Cindy McLaughlin

8/May/2023

Re: VA-23-00003 Sparks Park Variance

PRELIMINARY SITE PLAN
 MOUNTVIEW GROUP LLC TRAVEL CENTER
 WEST SPARKS ROAD
 EASTON, WASHINGTON

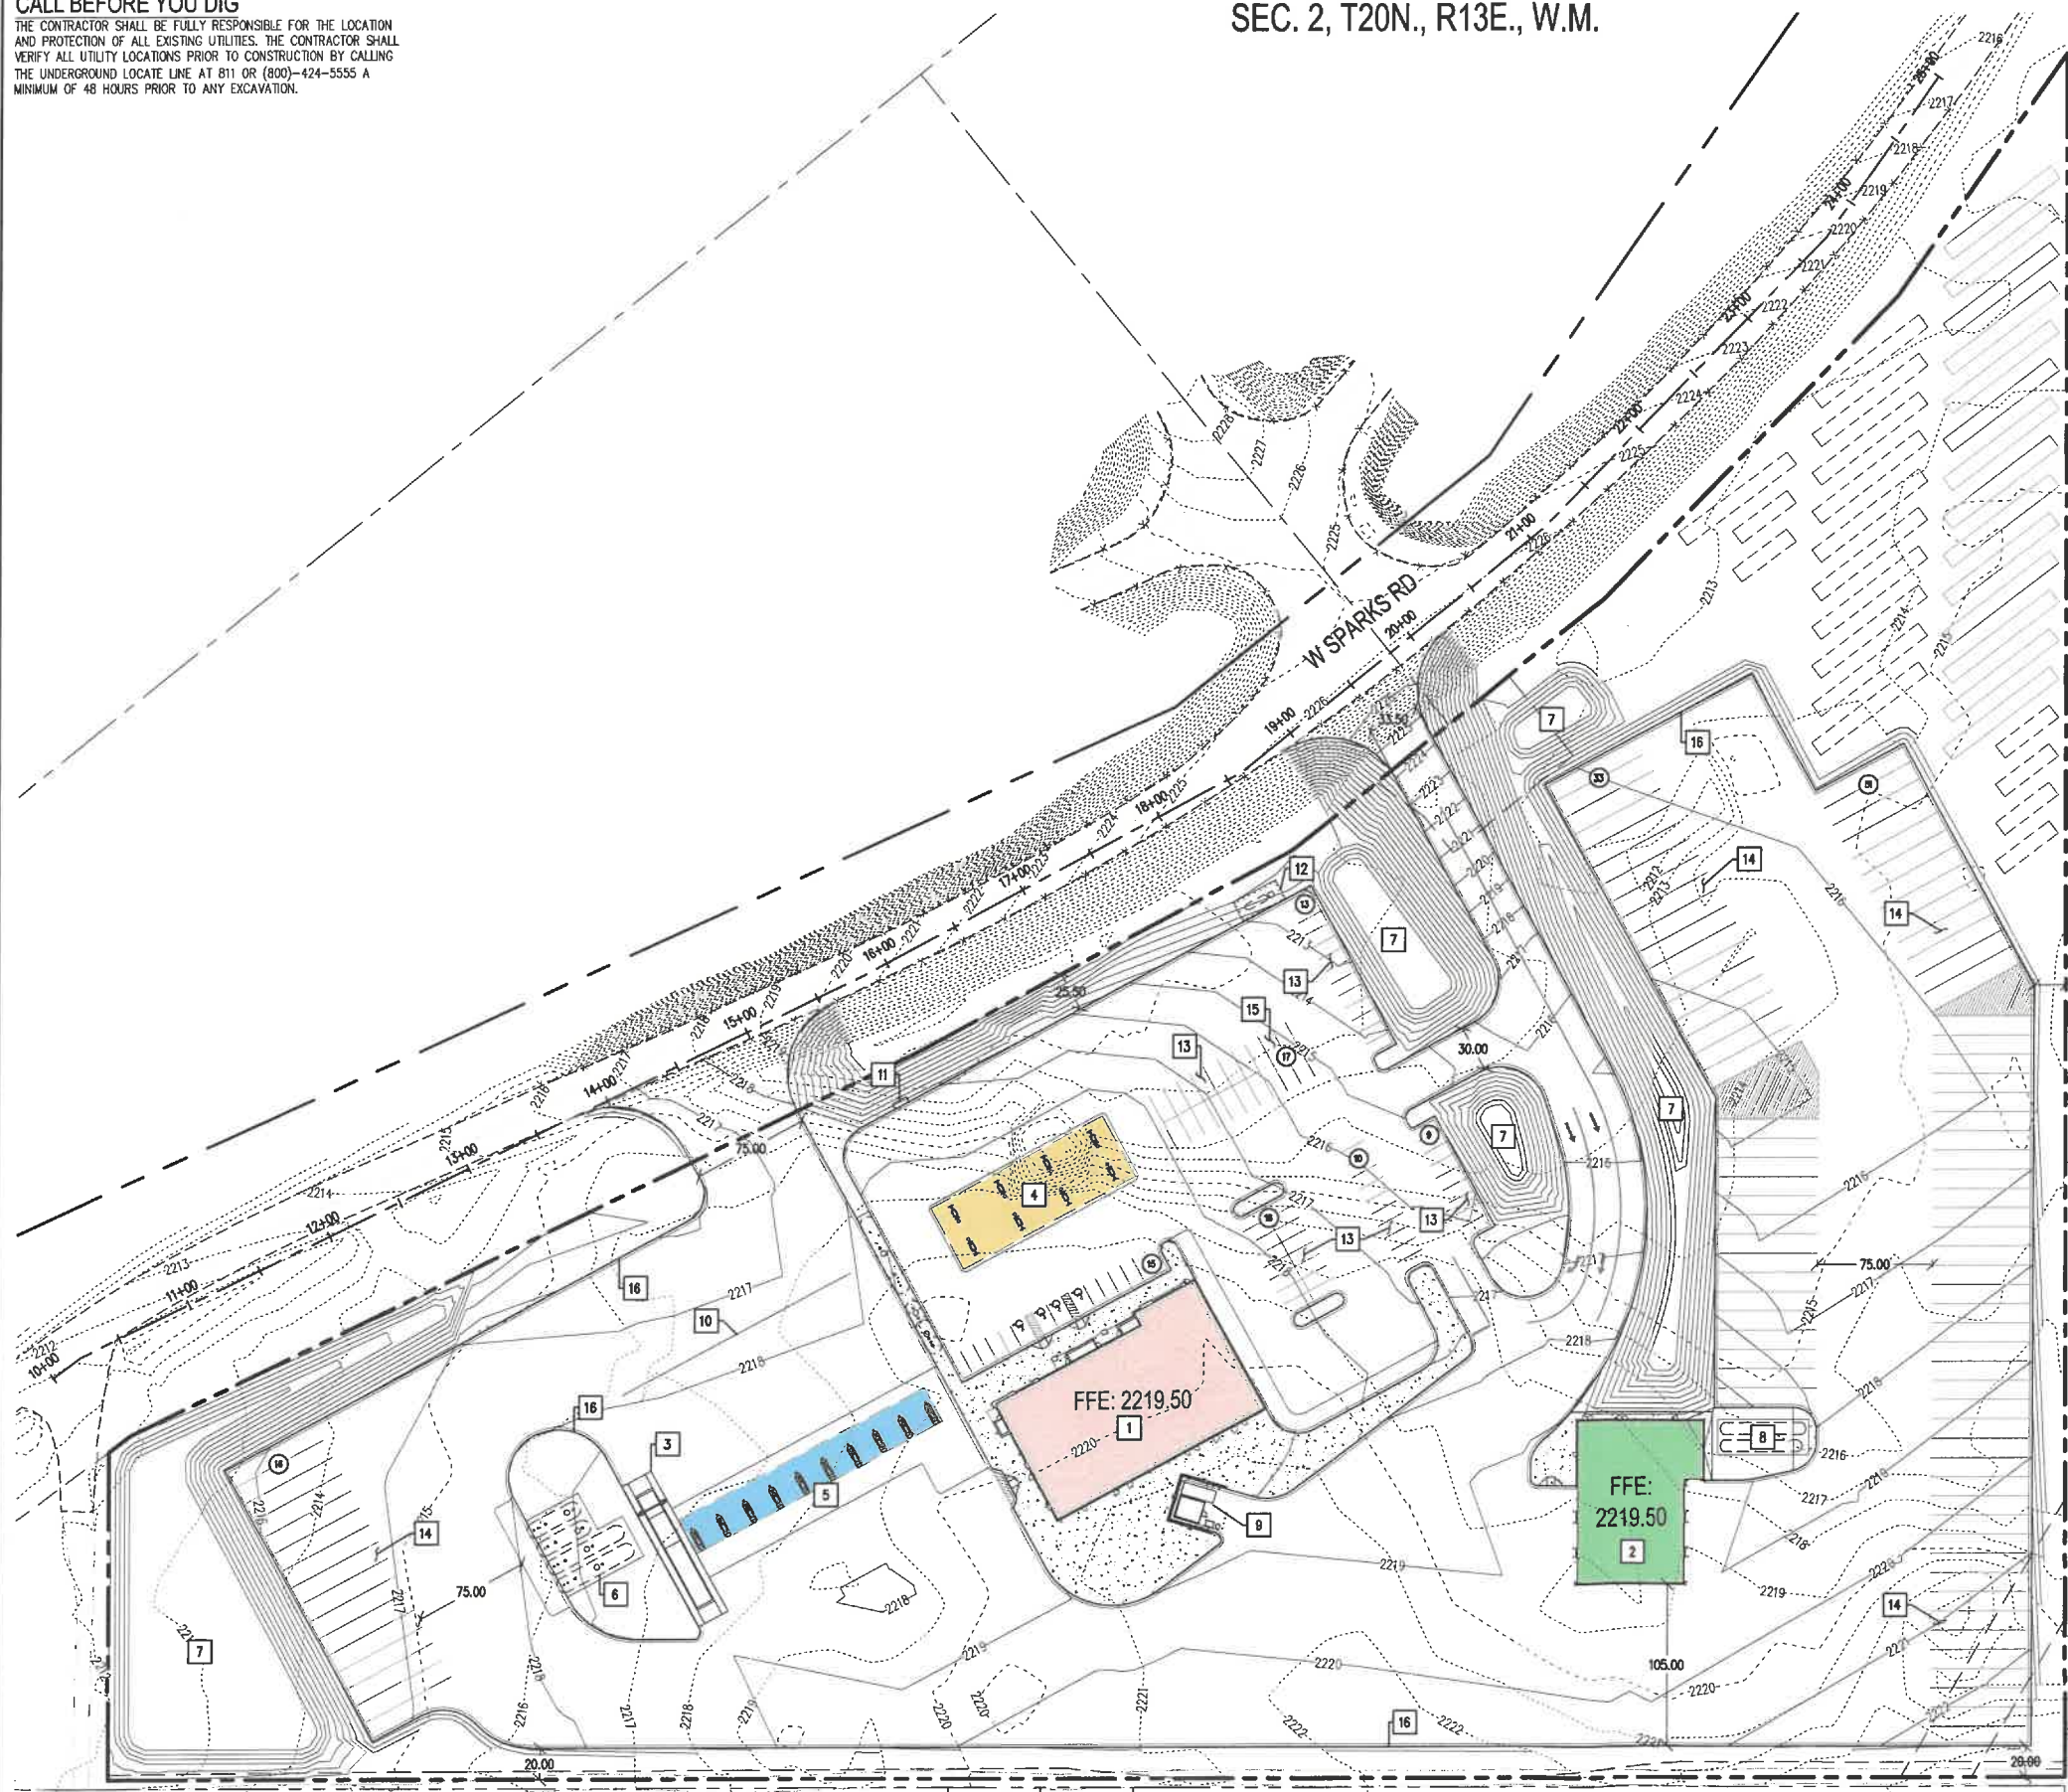
A Truck Stop: The request for a truck stop is one word "dispatched" away from being considered a "Freighting and trucking yard or terminal" which is an industrial use and is not authorized in the LAMIRD Type 3.

Retail Sales: General retail sales is implied to accompany the truck stop since it was included in the Zoning Variance Application Narrative from the applicant. The applicant should not be allowed to exceed the allowed use. **Note 48:** Permitted when conducted wholly within an enclosed building (excluding off-street parking and loading areas), provided the use does not exceed four thousand (4,000) square feet.

A Vehicle Repair Shop: Is not authorized unless; **Note 11:** Permitted when conducted wholly within an enclosed building (excluding off-street parking and loading areas)." This does not authorize the use of gas/fuel service stations since they cannot be fully enclosed. A canopy over the pumps doesn't constitute a wholly enclosed building.

Impervious Surfaces: The applicants plan is to surface all but 26% of the land. How can that possibly maintain a rural character? I have seen grocery stores with more rural character than this proposal.

Note: *All allowed uses within Type 3 LAMIRDs, other than manufacturing, outdoor recreation, and natural resource processing will be limited to 30,000 square feet in area, and that impervious surfaces on lots greater than one acre in size are limited to one third (1/3) of the lot.*
